WELWYN HATFIELD COUNCIL – DEVELOPMENT CONTROL
DELEGATED REPORT

APPLICATION No:	S6/2012/0338/LUP
APPLICATION Site:	45 Kentish Lane, Brookmans Park

DESCRIPTION OF PROPOSAL:

| PROJECT: Proposed extension, loft conversion & alterations | DRAWING NUMBER: 11015/9A |

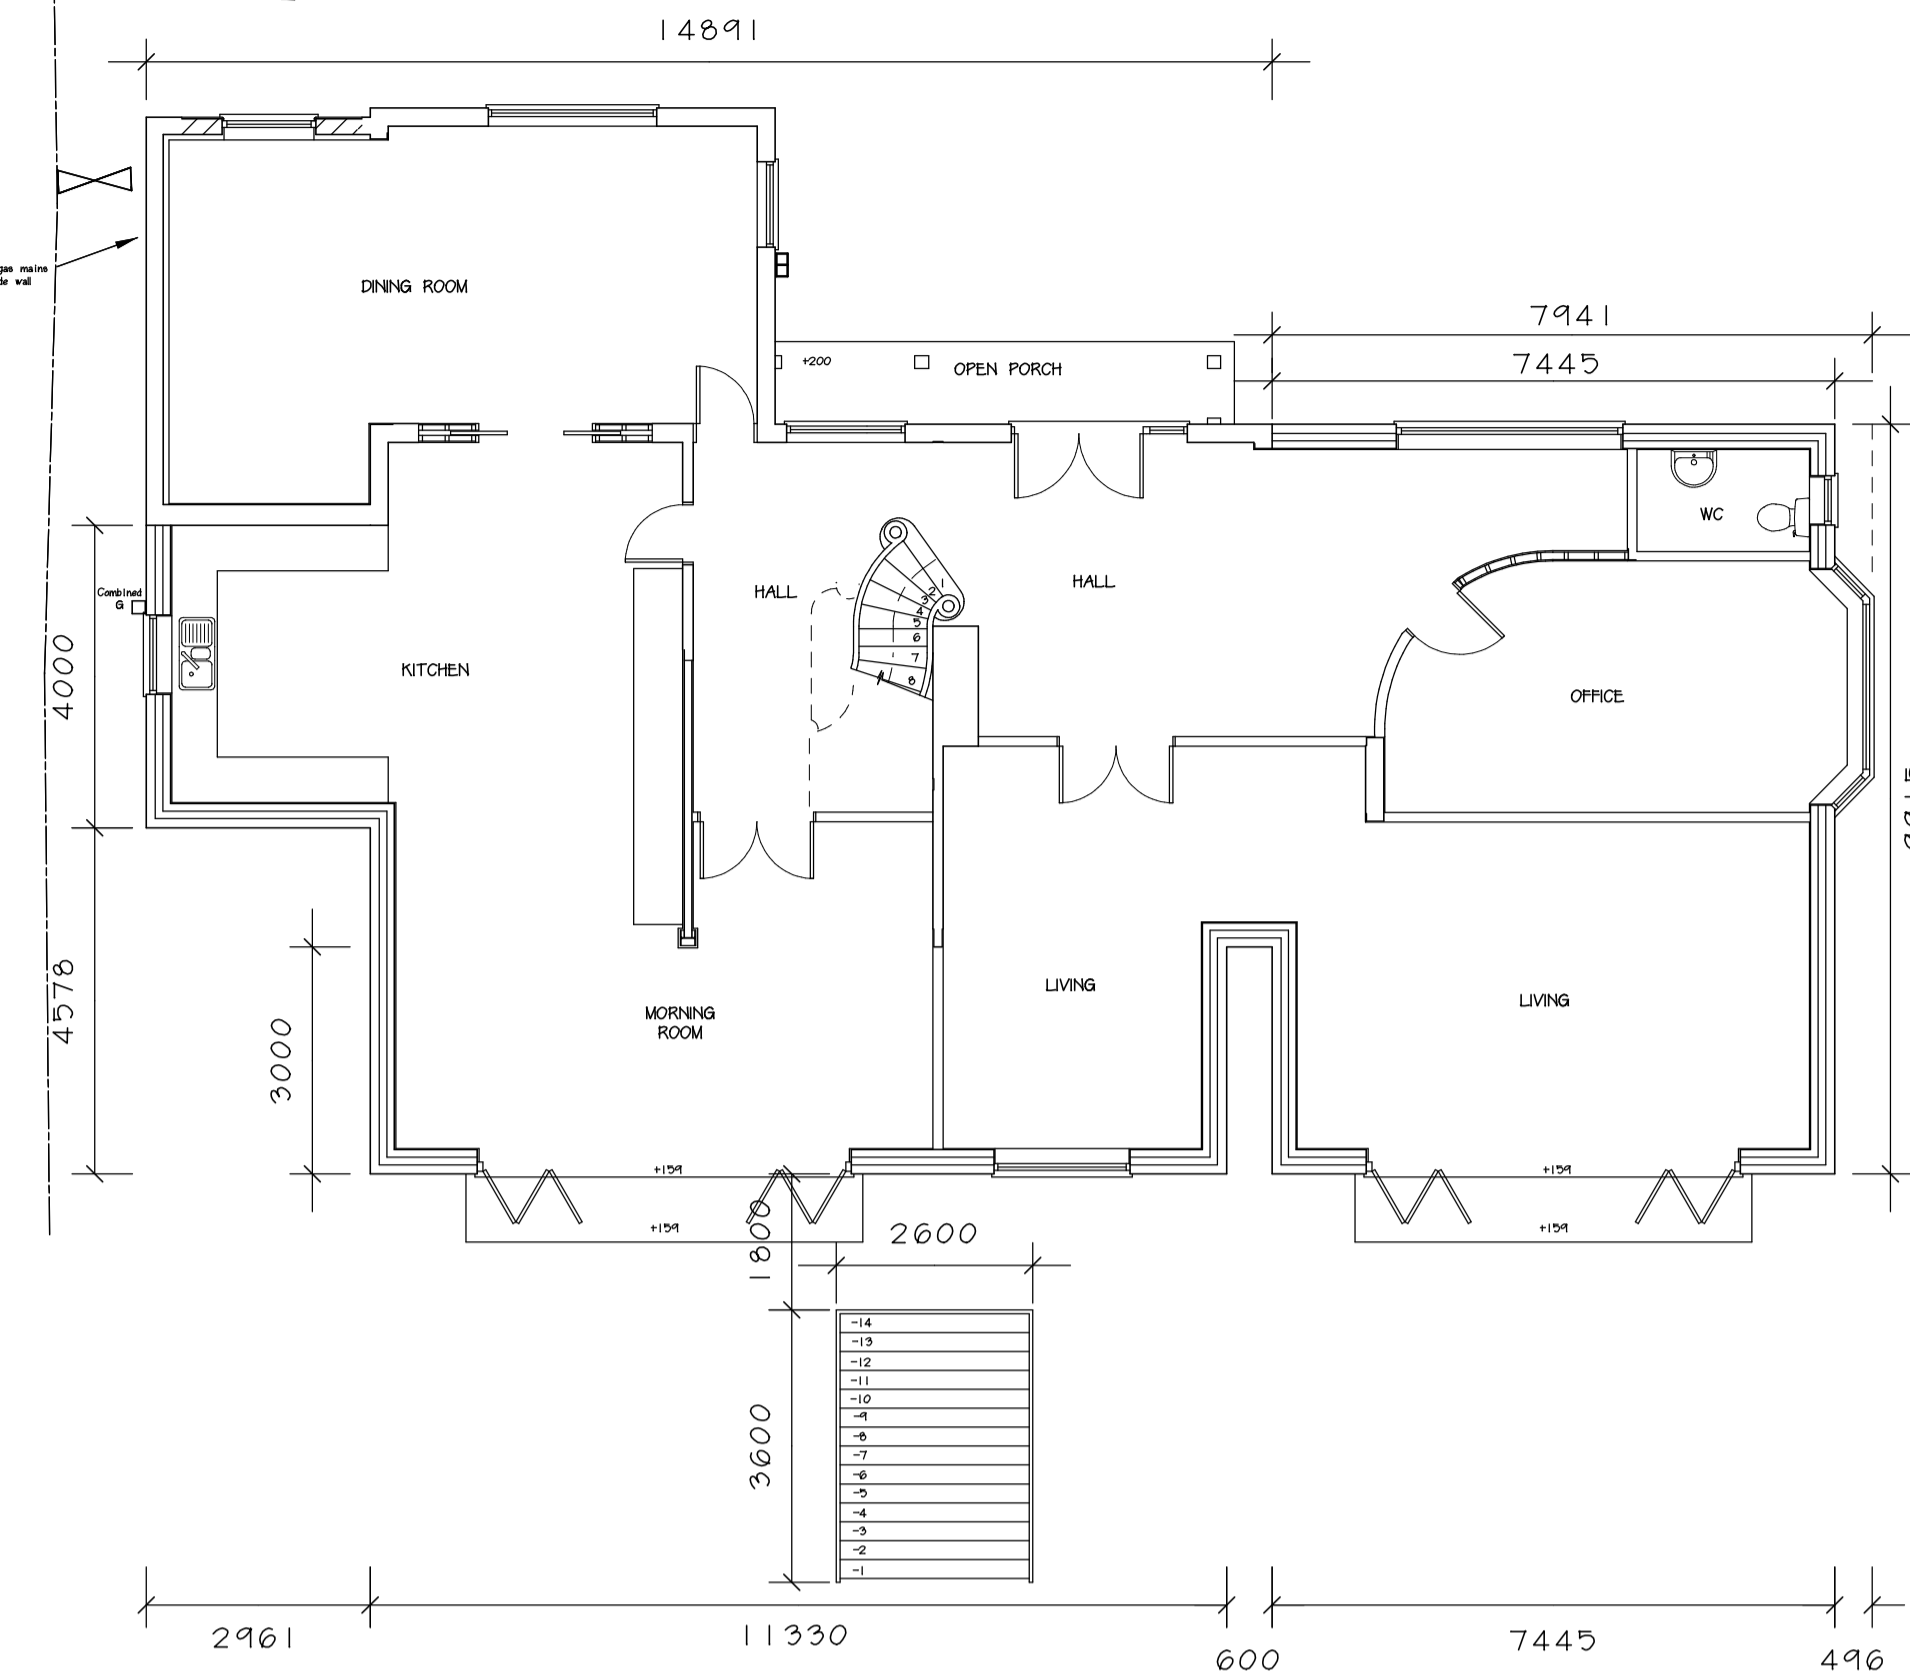
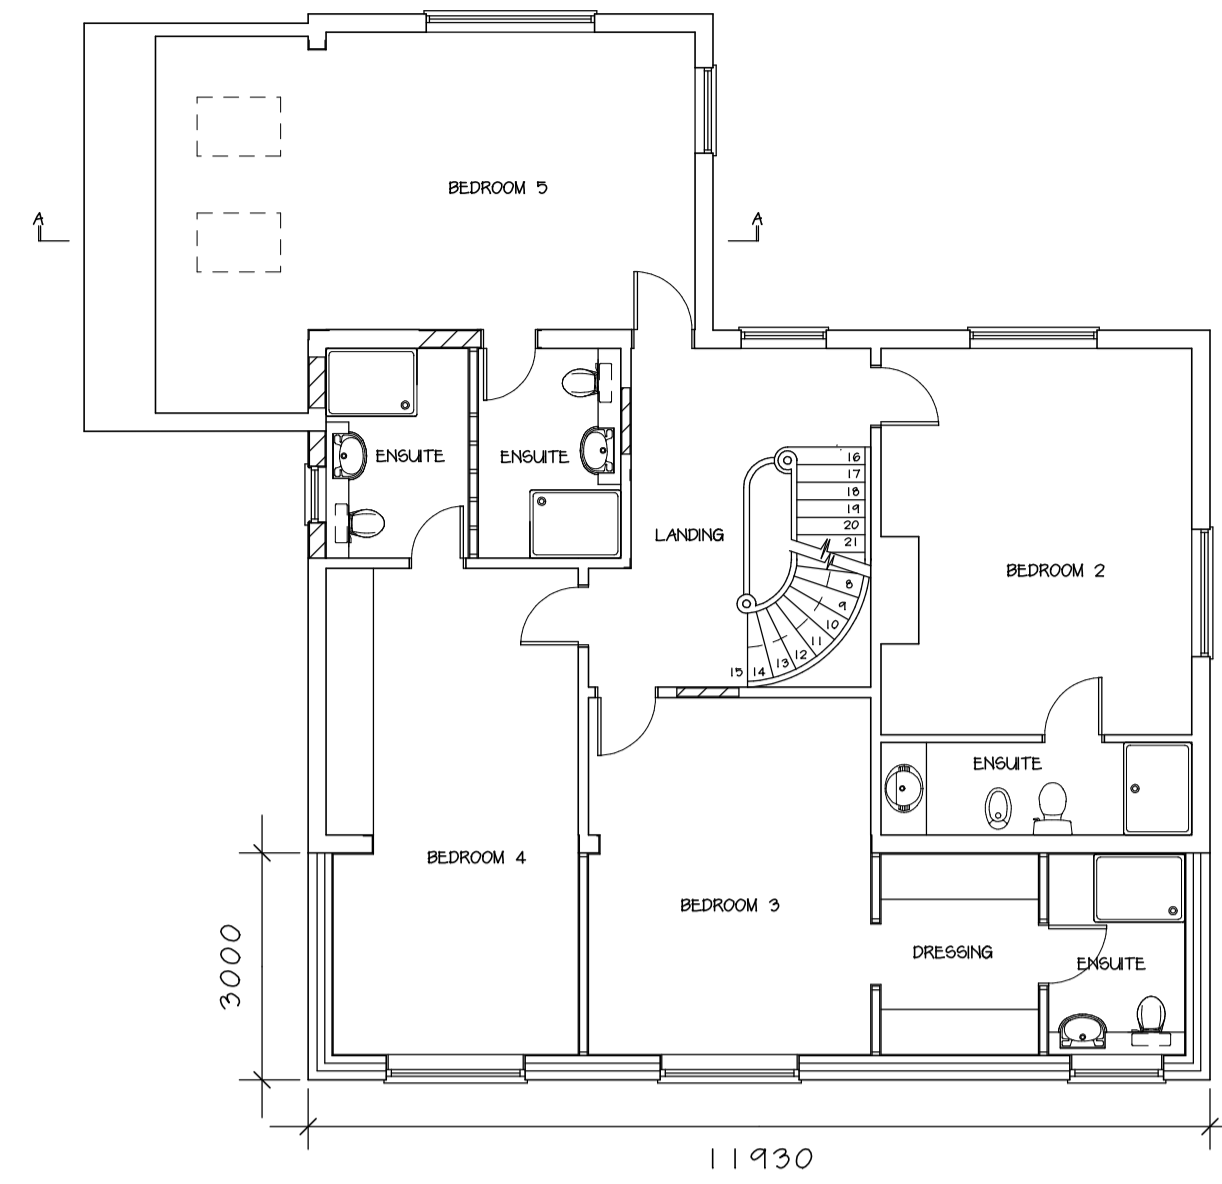
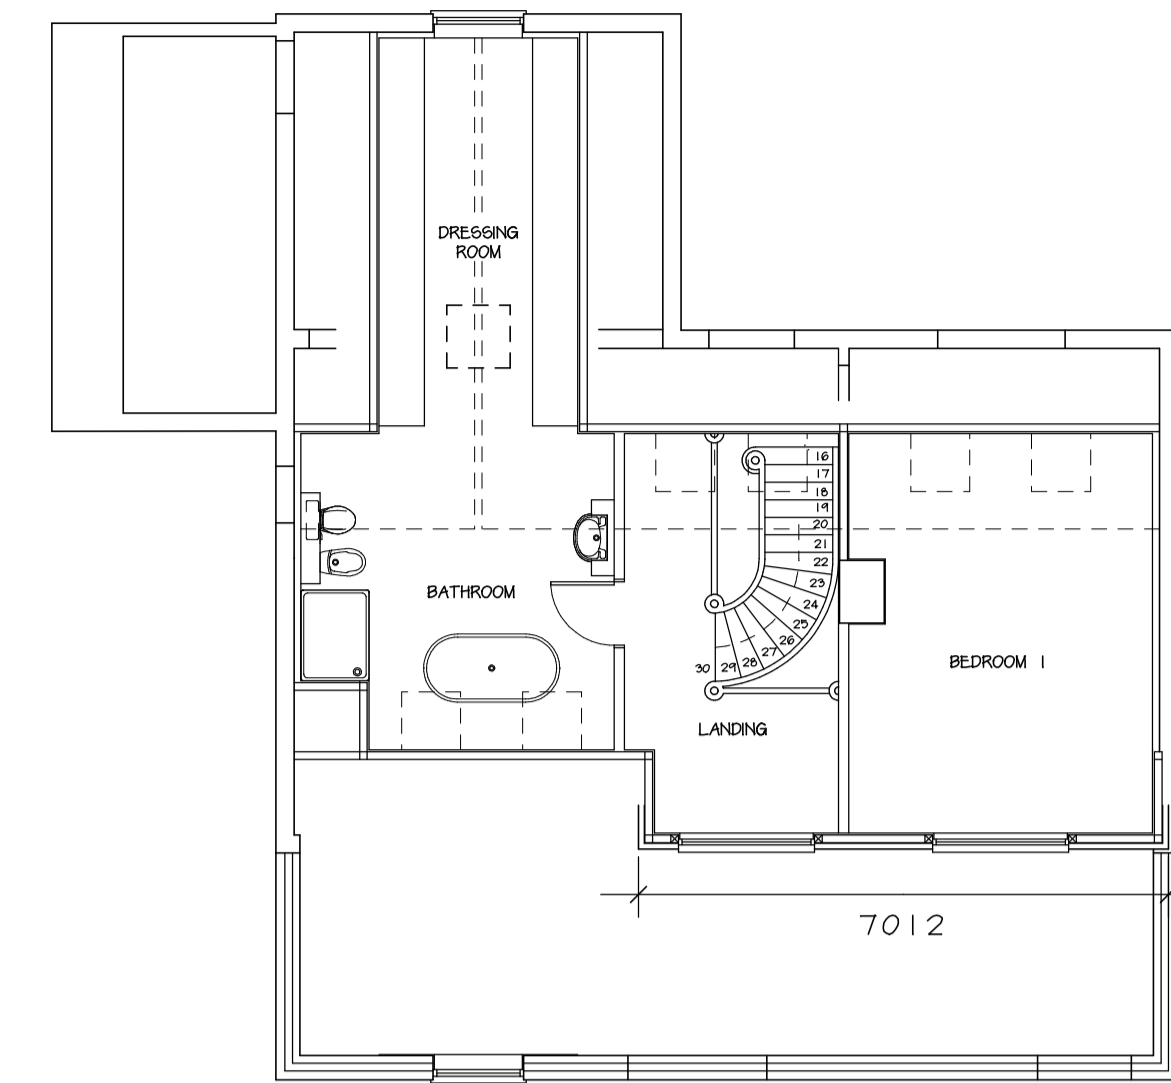
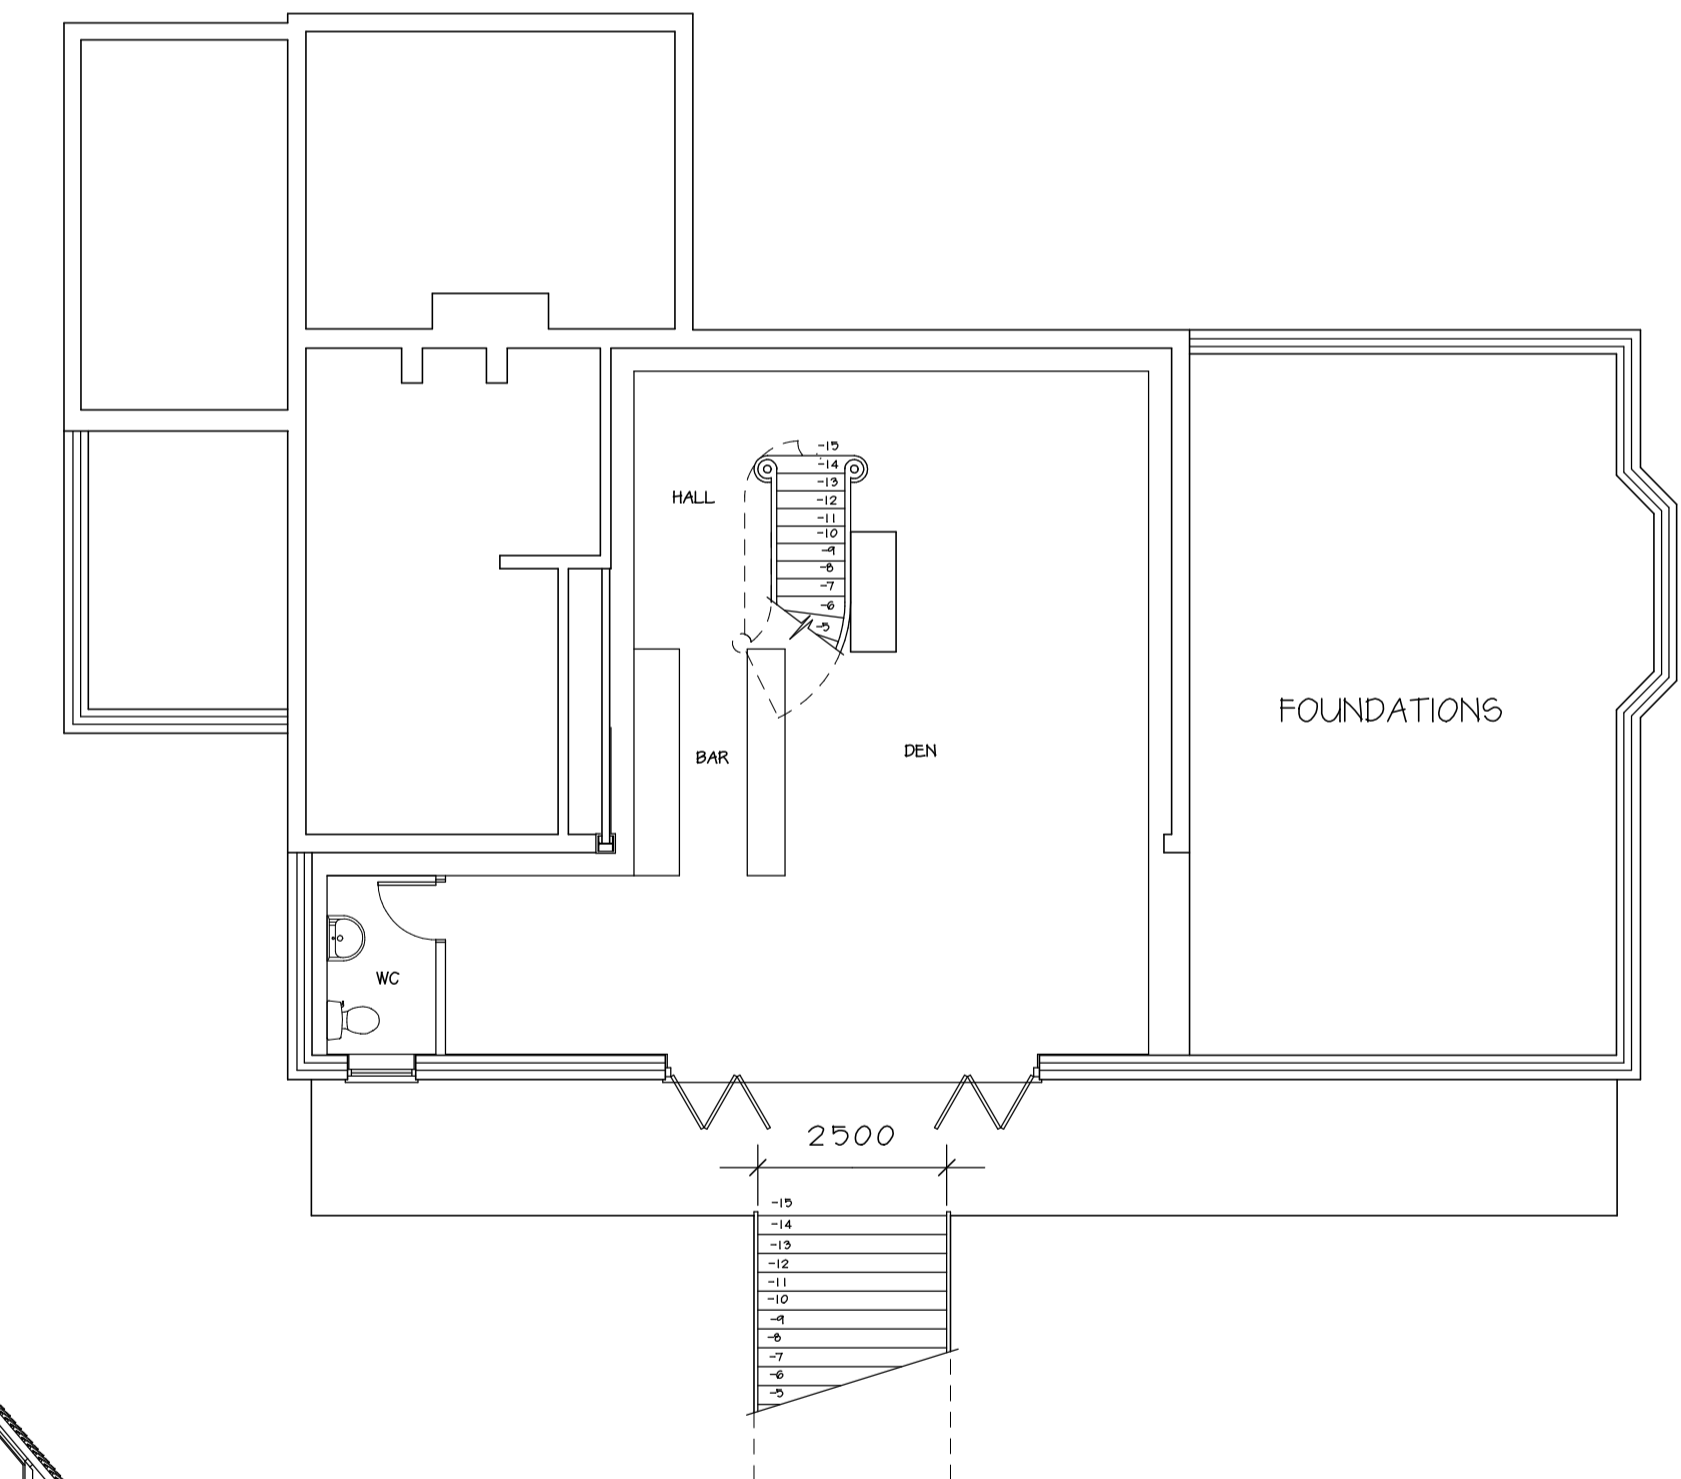
As part of the proposals, many of the internal walls are to be removed. However, for the purposes of this assessment, the proposed rear extension which would extend beyond the rear walls of the existing kitchen, WC, hallway and living room on the ground floor and bedroom 3, WC, bathroom and ensuite on first floor as shown on drawing 11015/9A would measure 3m in depth.

The proposed two storey rear extension measures more than 7 metres of any boundary of the curtilage.

The proposal also seeks to create a basement. The creation of basement falls under the consideration of Class A as it is an enlargement of a dwellinghouse. In this case, the basement in combination with the two storey rear extension above ground level would accumulate in an extension which is more than one storey. However, the basement in addition to the two storey rear extension would not extend more than 3m from the rear wall or be within 7m from any boundary opposite the rear wall

The applicant has not submitted roof volume calculations.

Rear dormer window: (w) 7m x (h) 2.9m x (d) 2.5m / 2 = 25m³

Hip to gable enlargement: (w) 3.7m x (h) 4.5m x 7.14m / 6 = 19.8m³

Total additional roofspace: 44.8m³

The proposal therefore complies with Class B (c) by virtue of the additional volume of the roofspace not exceeding 50m³ upon the roofspace of the original dwelling
